Traffic & Safety - Access Permits

December 8, 2024

RE: PPR-2422 UDON RV Storage (Southside of SH 94)

The submittals for UDON RV Storage received on September 3, 2024 have been reviewed by CDOT Access Management. Our comments follow:

FIGURE 17
 UDON REZONE
 EL PASO COUNTY, COLORADO
 2026 RECOMMENDED GEOMETRY &
 CONTROL – PHASE 1

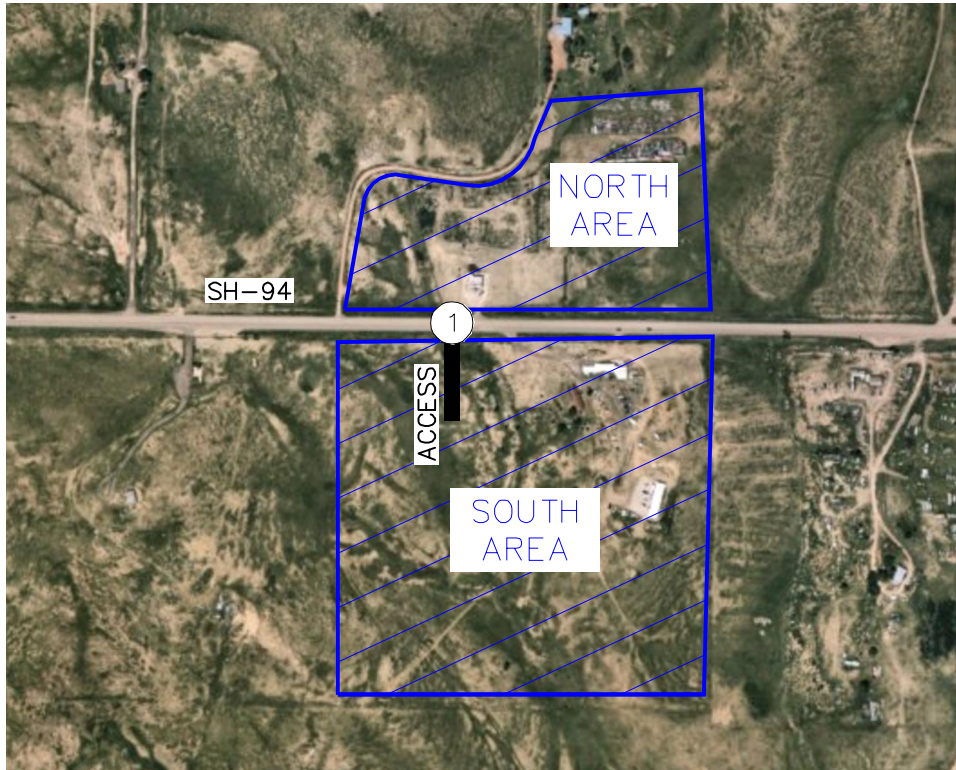
- The access will initially be a T-intersection with only the south area developing in Phase 1.
- Three CDOT Access Permit Applications have been received and are being processed.

FIGURE 19
 UDON REZONE
 EL PASO COUNTY, COLORADO
 2028 RECOMMENDED GEOMETRY &
 CONTROL – HIGHEST USE

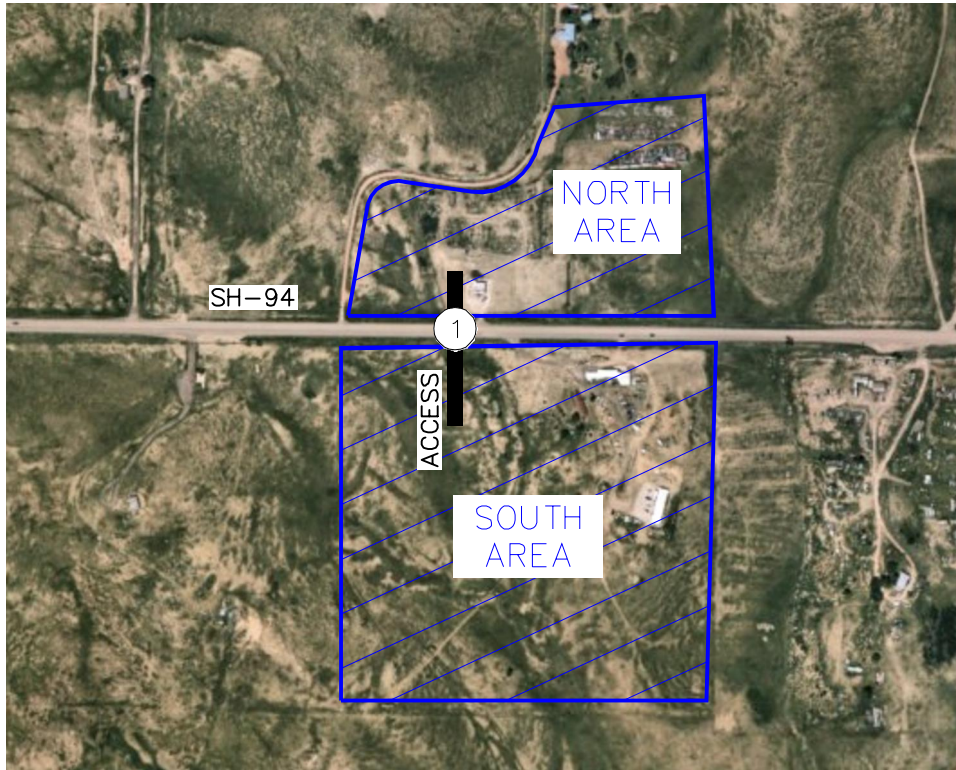
- Given that this application is for a rezone to commercial use, CDOT Traffic anticipates that at full build out the access will warrant auxiliary lanes and an intersection control analysis. CDOT Traffic agrees that no improvements for the storage units are warranted.
- As development continues, additional review from CDOT is required.
